Our Ref: Y/37/26/NMA

**Section 96A of the Town & Country Planning Act 1990 (as amended)
Town and Country Planning (Development Management Procedure) (England) Order 2015
(as amended) - Article 10**

Non material amendment following the grant of Y/53/25/HH for proposed widening and change from pitch to flat roof to single storey rear extension.

Flints Hoe Lane Flansham PO22 8NP

Proposed North Elevation

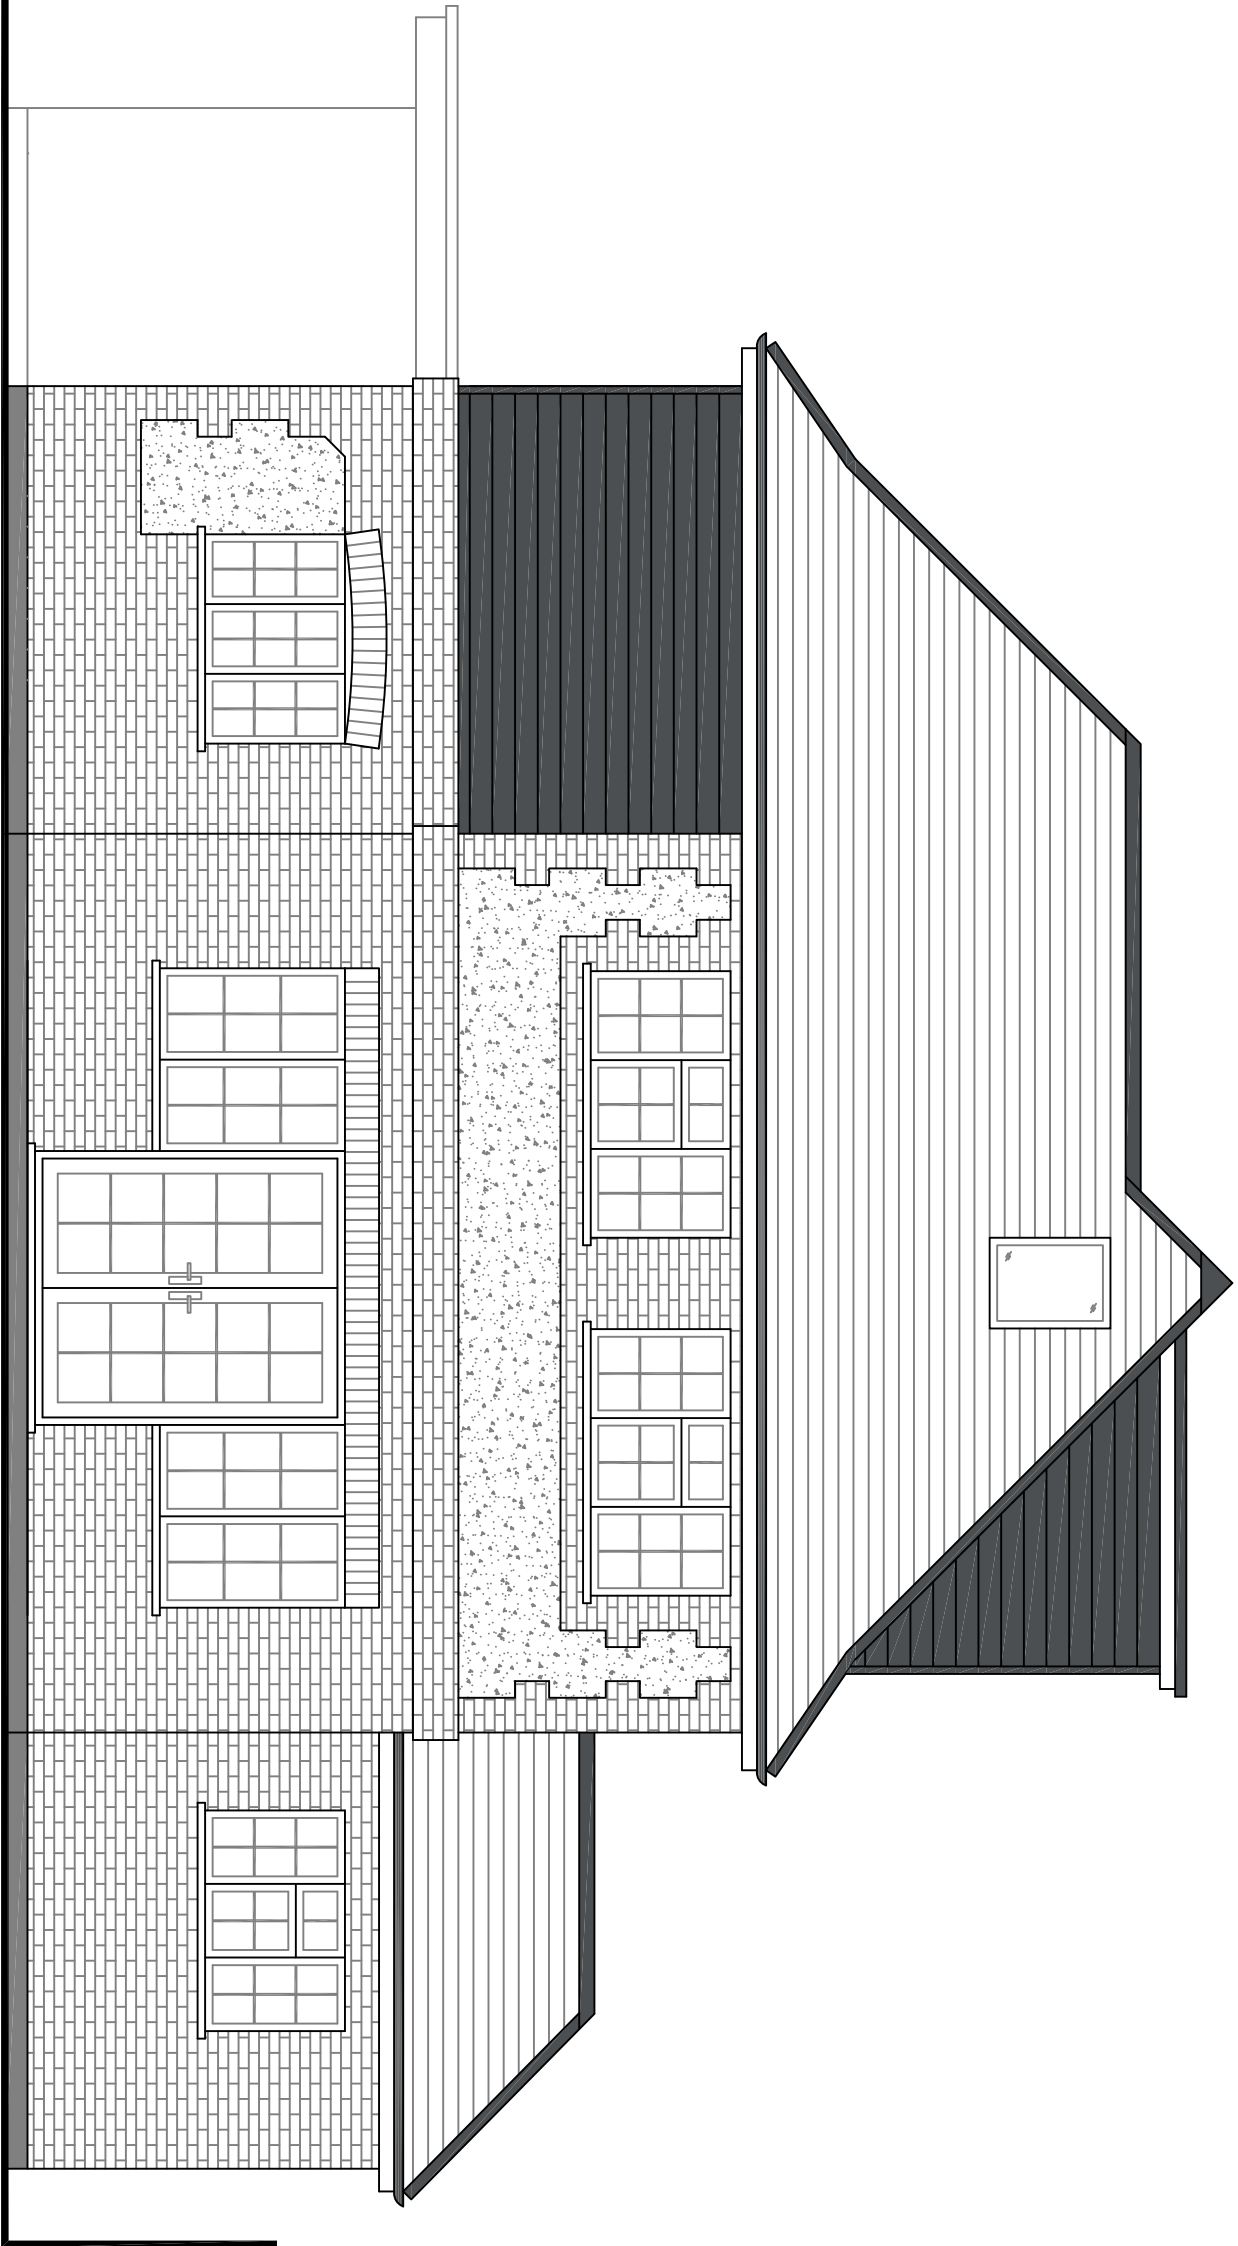
The reason that this proposal has not been accepted as a Non-Material Amendment is because it would result in a significant increase in width, and as such would result in a materially different appearance to that previously approved. It cannot therefore be considered under section 96A of the Town and Country Planning Act 1990.
